**re: Geotechnical Response to City Comments
Zoning By-law Amendment Application**
6208 Renaud Road, Ottawa, Ontario

date: January 4, 2024

file: PG6640-MEMO.01

Further to your request and authorization, Paterson Group (Paterson) prepared the following memorandum to provide geotechnical responses to the City of Ottawa comments related to file No. D02-02-23-0053 dated October 20, 2023.

HOLE NO.
BH 1-23

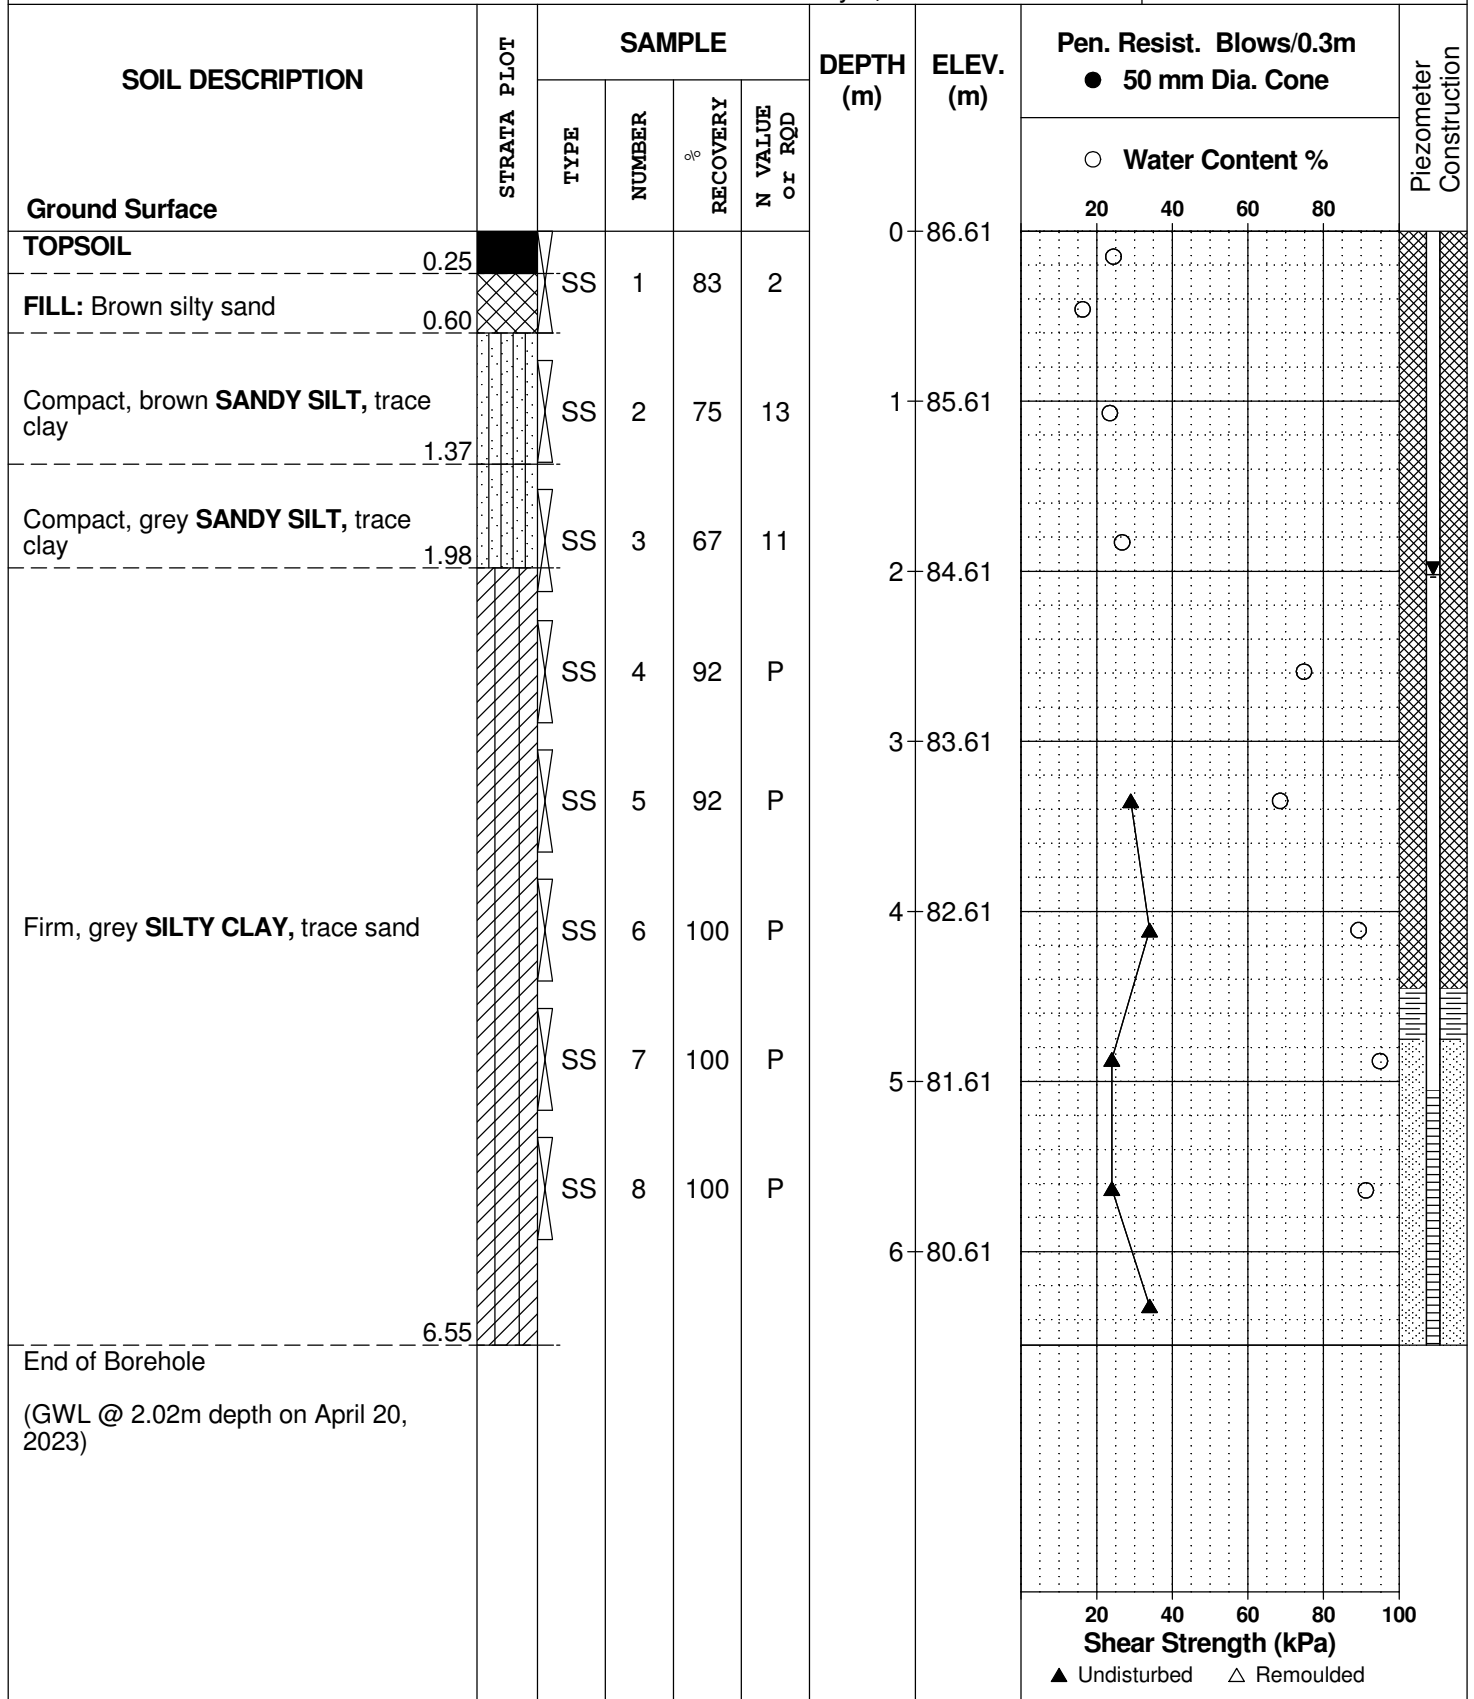
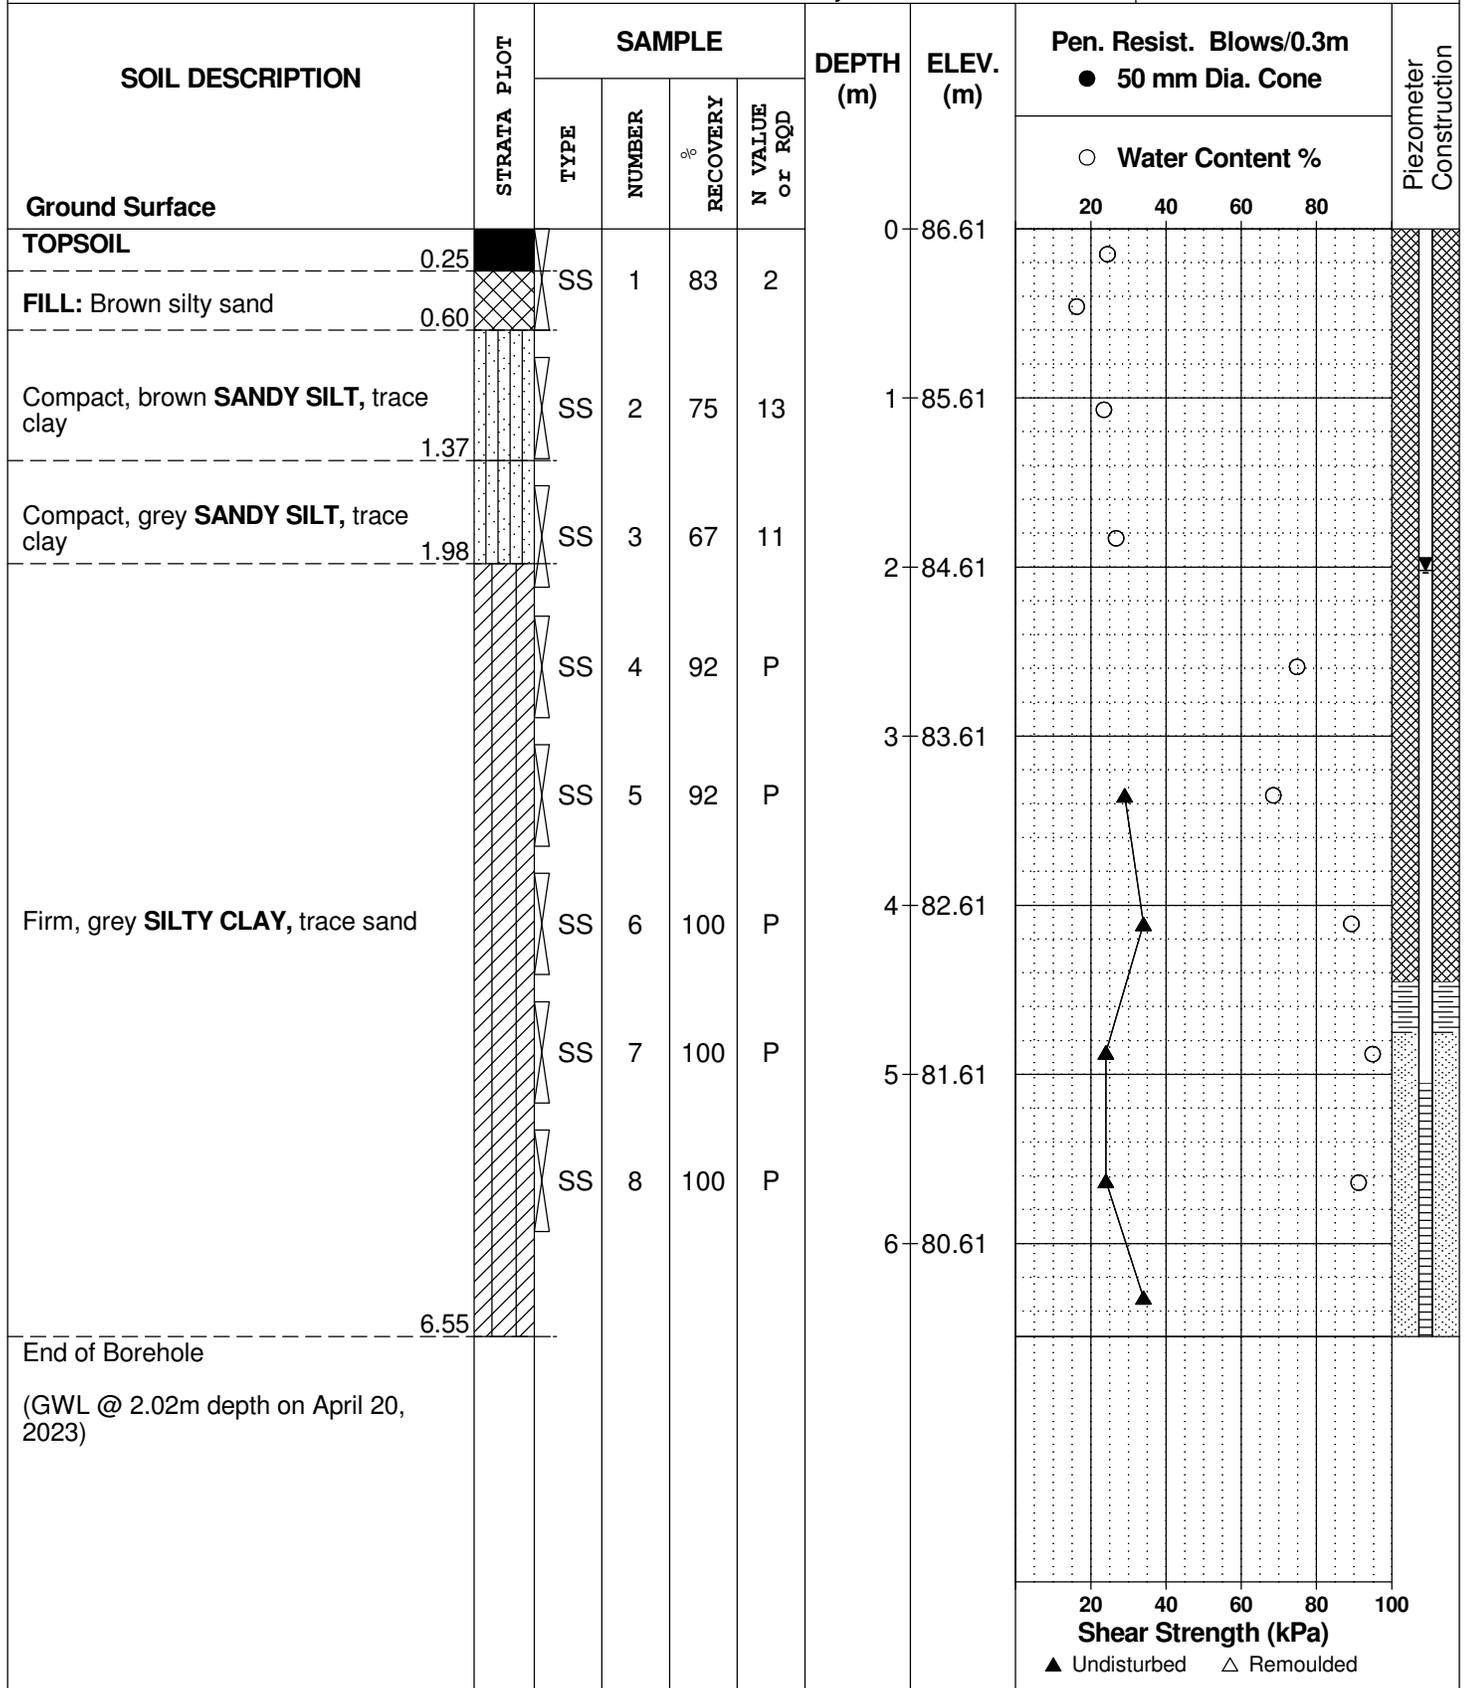
Comment 1.C.2: *In section 4.2, the reporting should include detailed discussion for the results of the Atterberg Limits testing, including the water content measured in the BH 1-23 and BH 2-23, which measured water content more than 80% at 4m depth and below.*

Comment 1.C.5: *In BH 1-23, the remoulded shear strength was measured in only one location where the moisture content was measured between 50 and 55%. It is expected that remoulded shear strength measurements in conservative locations, i.e. where the moisture content is above 80%, would be provided. Soils at that depth may be above the liquid limit, and there is potential for significant loss in strength and consolidation when subject to new static or seismic loading conditions.*

Comment 1.C.6: *In BH 1-23 and BH 2-23, the N value is noted as either 1 or 'P' (assuming P is in reference to 'pass') from approximately 2 metre depth to the end of the borehole. The results of the Standard Penetration Testing should be discussed in the determination of the consistency (section 4.2) and bearing resistance values (section 5.3). In the symbols and terms sheet, an N value below 2 would seem to indicate a very soft or soft consistency. Please include the value of 'P' in the borehole log or legend to confirm.*

Response: Please refer to Section 4.2 of the Paterson Group Report PG6640-1 Revision 1 dated January 4, 2024. The high water content are indicative of an extra sensitive silty clay deposit. This type of findings is not uncommon in the area studied and does not cause any issues to light residential construction. Special considerations would be required for deep excavation or service installation which are not proposed for this site, except for the servicing connection, discussion for deep trenching is included under Section 6.3.

Response: Remould values were only obtained at one sampling location due to the vane apparatus moving after the initial undrained shear strength testing, which is common for sensitive silty clays. Once the vane apparatus moves excessively during the testing, a remould value cannot be obtained.

Response: The value of "P" noted for the sampling completed at the subject interval refers to "Push" indicates that the split spoon sampler was pushed through the disturbed soil to collect a sample following a vane test. The soil at the subject interval was disturbed due to the completion of the in-situ vane shear test. The consistency and bearing resistance values of cohesive soils (silty clay deposits) is better defined with undrained shear vane values which were collected at the subject sampling intervals.
